2024/1035

114 Keresforth Road, Dodworth, Barnsley, S75 3NX

**Removal of precast concrete garden store and erection of prefabricated timber garden room**

Ashton 10' x 8'

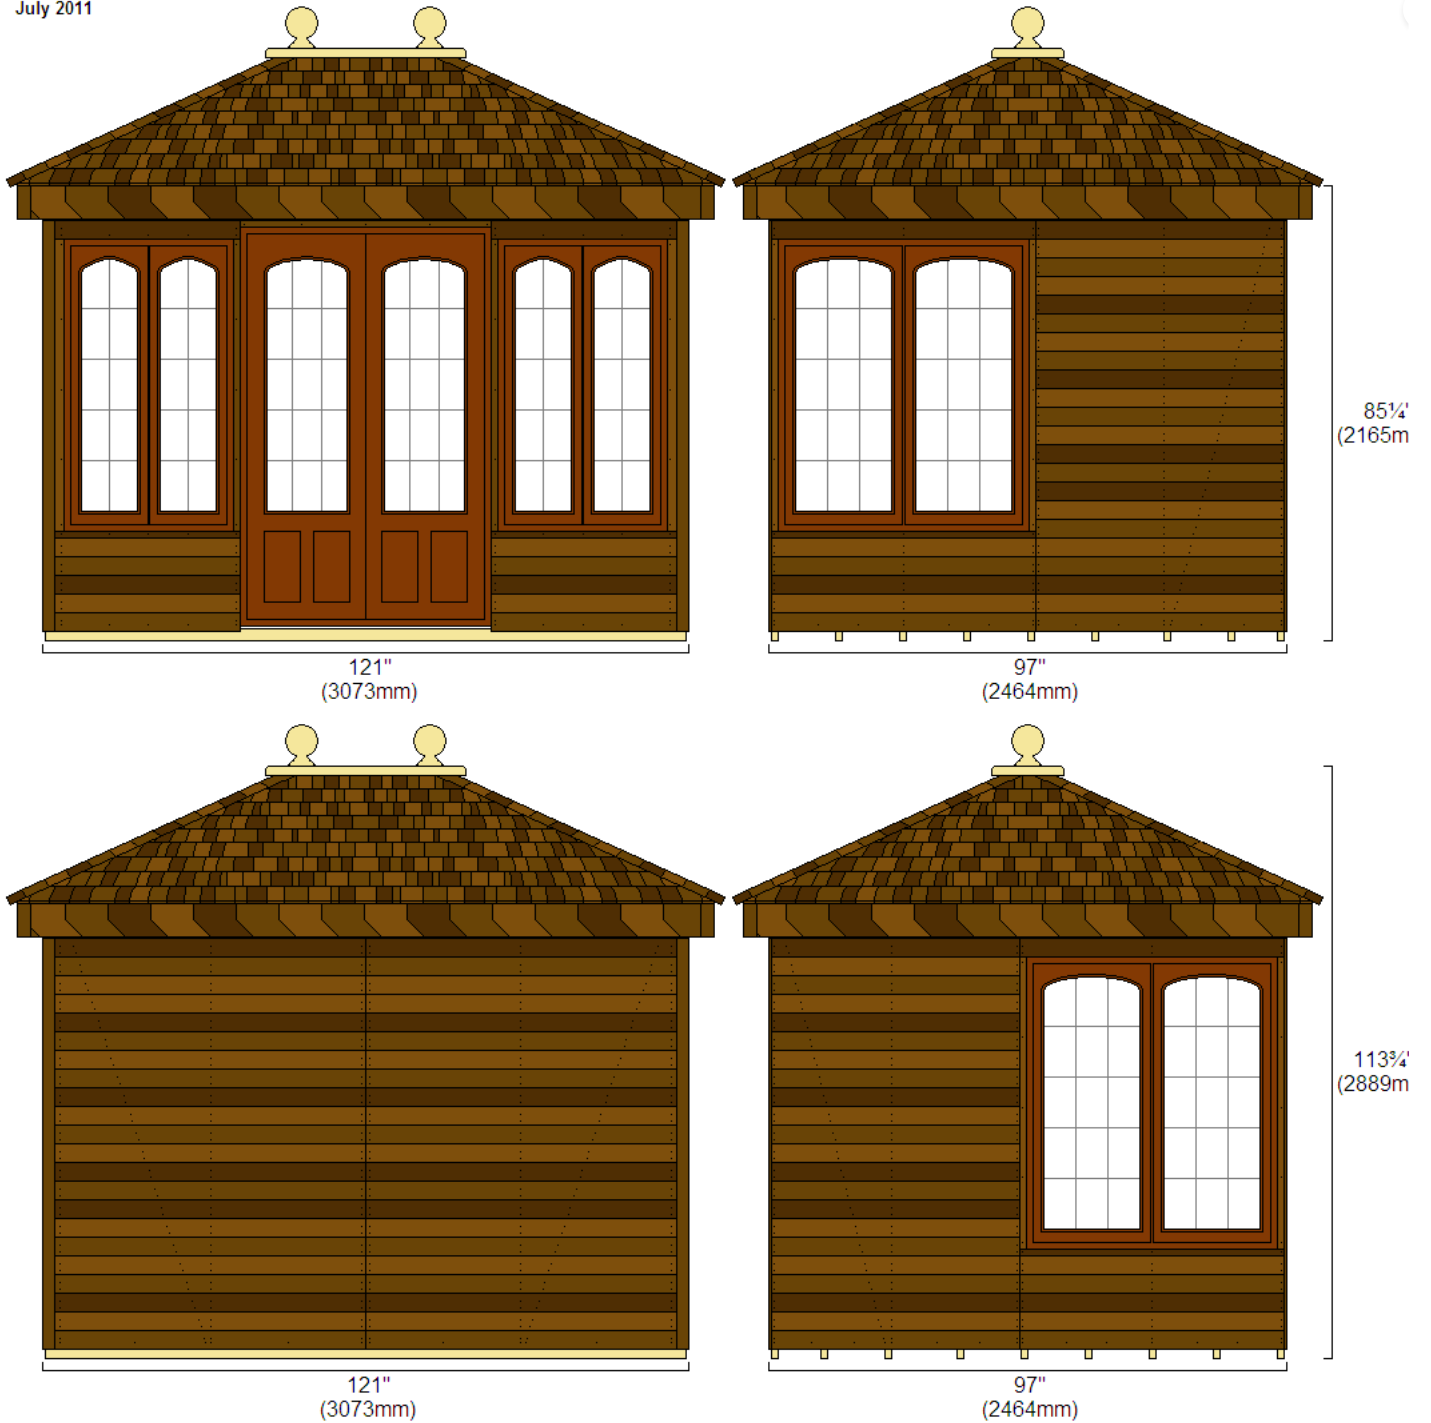
The proposed garden room would have a hipped roof with an approximate ridge height of 2.9 metres and an approximate eaves height of 2.2 metres. A width of approximately 3.1 metres is proposed with an approximate length of 2.5 metres. Glazing is proposed to the front elevation along with glazed doors located centrally. Glazing is proposed to the front of the side elevation approximately 1.2 metres in width. The garden room is proposed to be built from prefabricated timber tongue and groove board. The roof is detailed to use mineral felt shingles over timber.

The garden room is below the maximum 2.5 metre eaves height and is below the maximum 4 metre ridge height outlined within the House Extensions and Other Domestic Alterations SPD. Although matching materials are not used, it is acknowledged the garden room is a prefabricated building and so it would not be reasonable to require matching materials. Additionally, the garden space within which the garden room is proposed is substantially screened from public view. A hipped roof form is preferable to a commonly used flat roof. If a flat roof was used, the proposal would not require planning permission. The use of a hipped roof is therefore welcomed and matches the site and neighbouring dwellings. This therefore substantially weighs in favour of the proposal.
